From: Tim Screen
Sent: 24 June 2020 17:29
To: Rebekah Morgan
Subject: FW: 16/00472/OUT - S Grundon Services Ltd, Merton Street, Banbury

Tim Screen CMLI
Landscape Architect
Environmental Services
Cherwell District Council

Proposed Section A-A

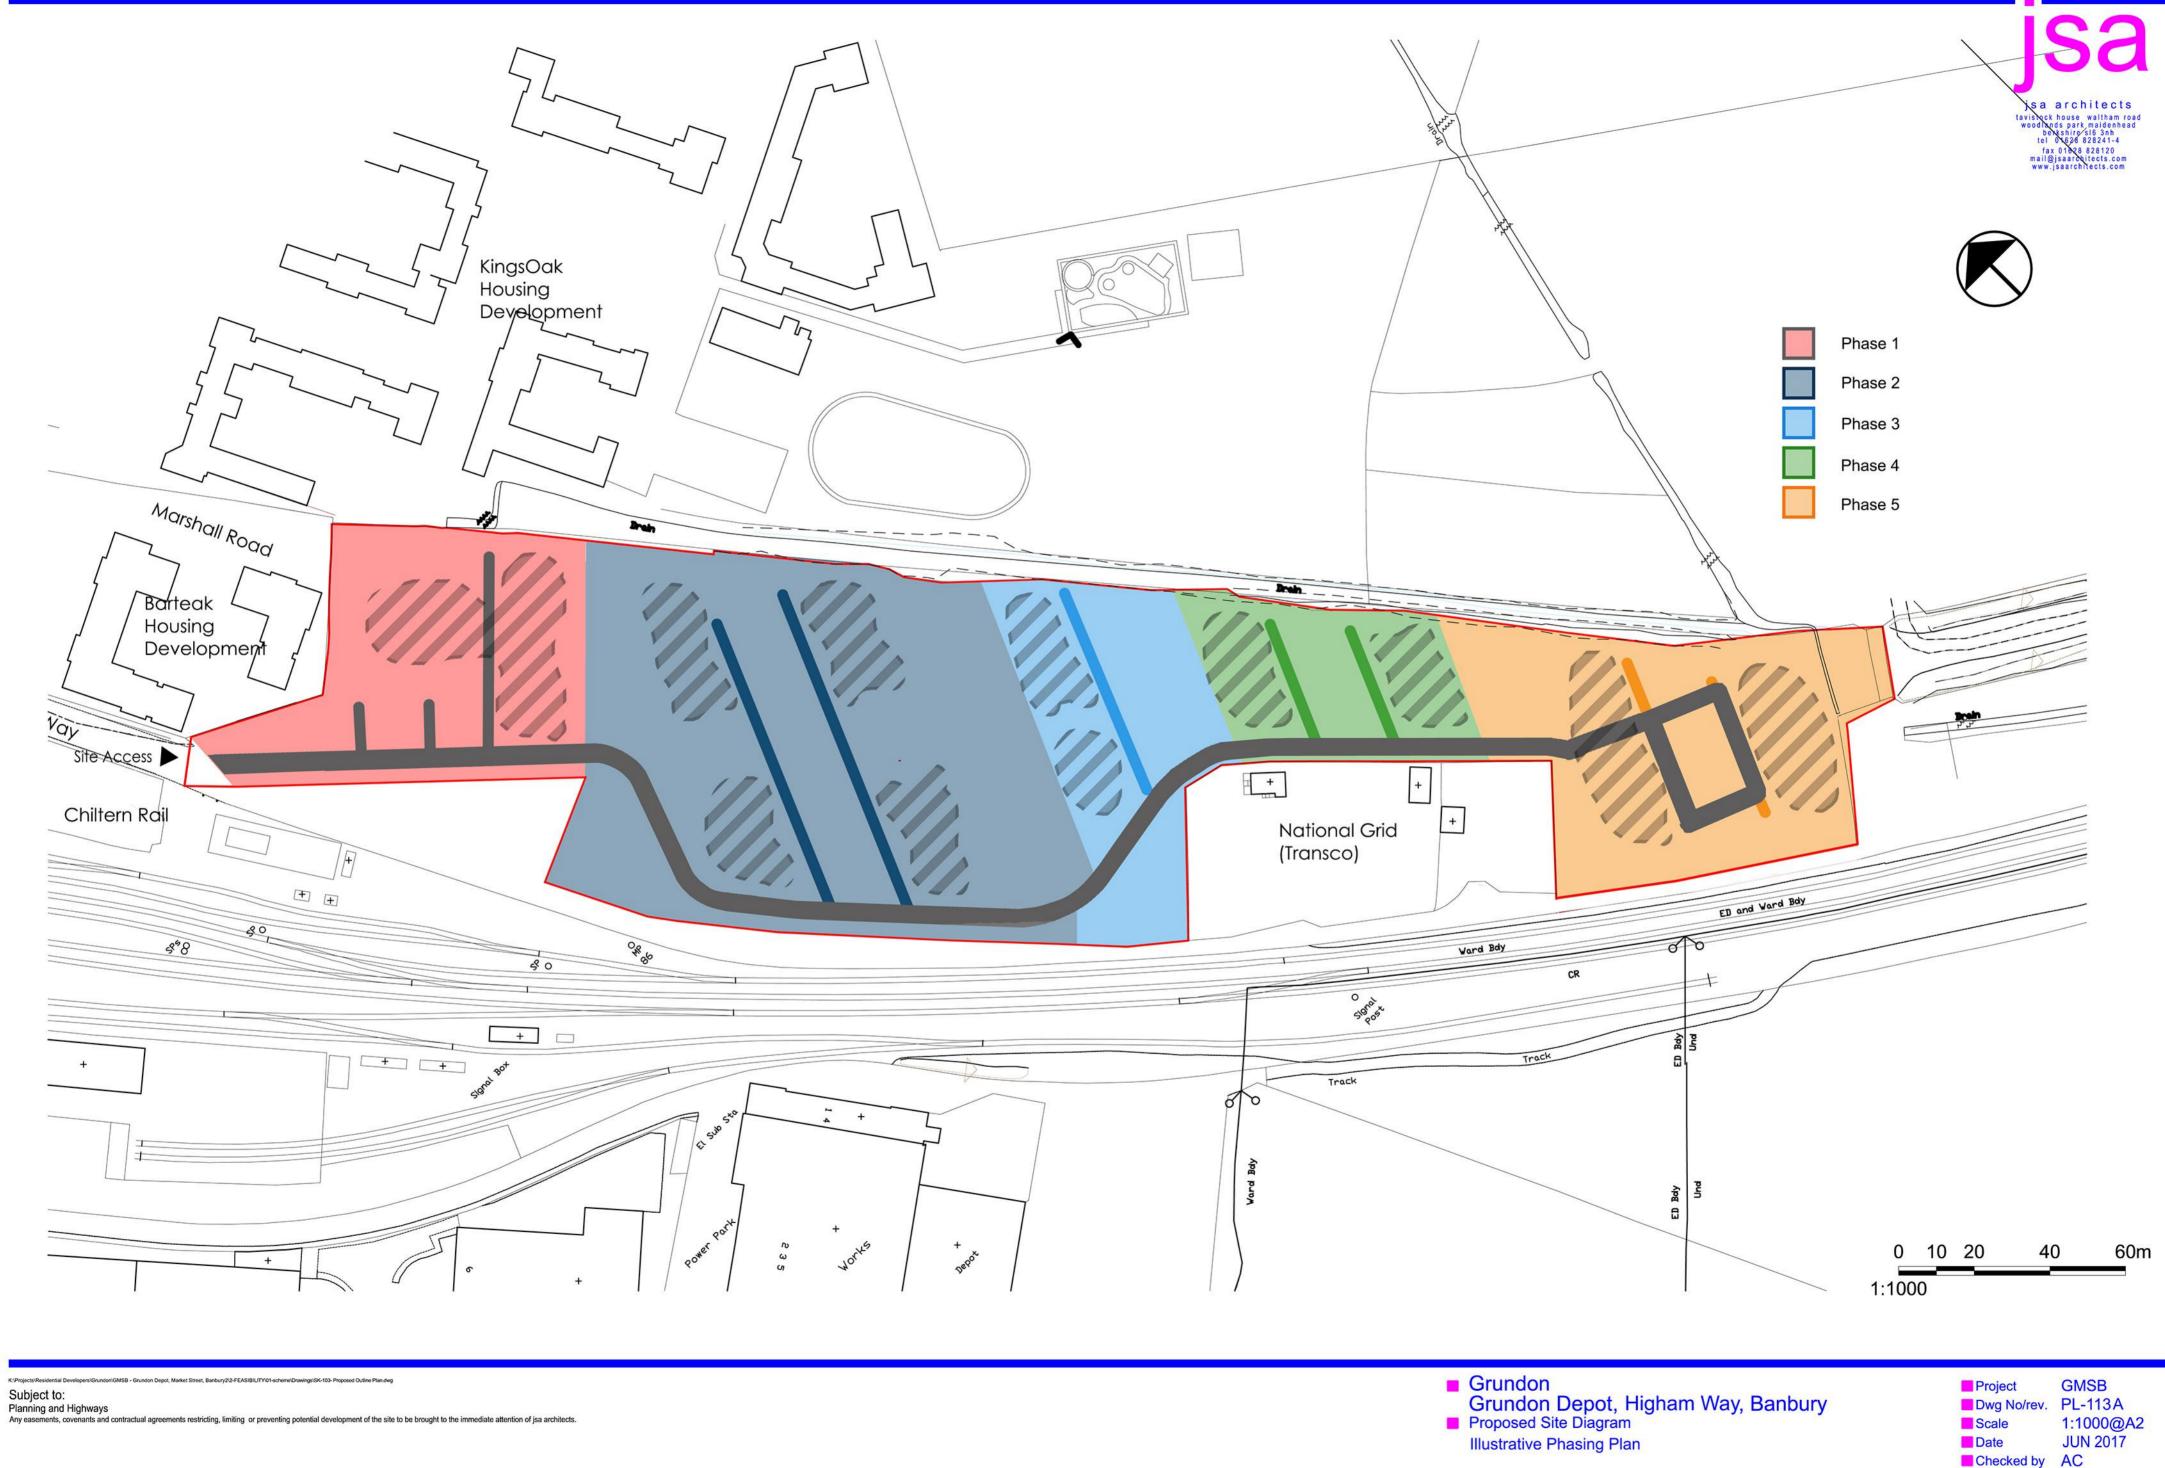
Adrian James Acoustic report mentions a 6 m high acoustic wall. The wall be visually harmful and physically oppressive for residents. The feature would require extensive landscape mitigation, along with a 3 m wide maintenance access route along its length. Cross-sectional construction details are required. A positive response from the developer in respect of ownership/responsibility of the acoustic wall is necessary. This is not a feature that CDC would wish to manage and maintain. National Rail or its subsidiary should take on this responsibility. This must be clarified in the 106 agreement (there appears to be no 106 agreement on the DEF database)
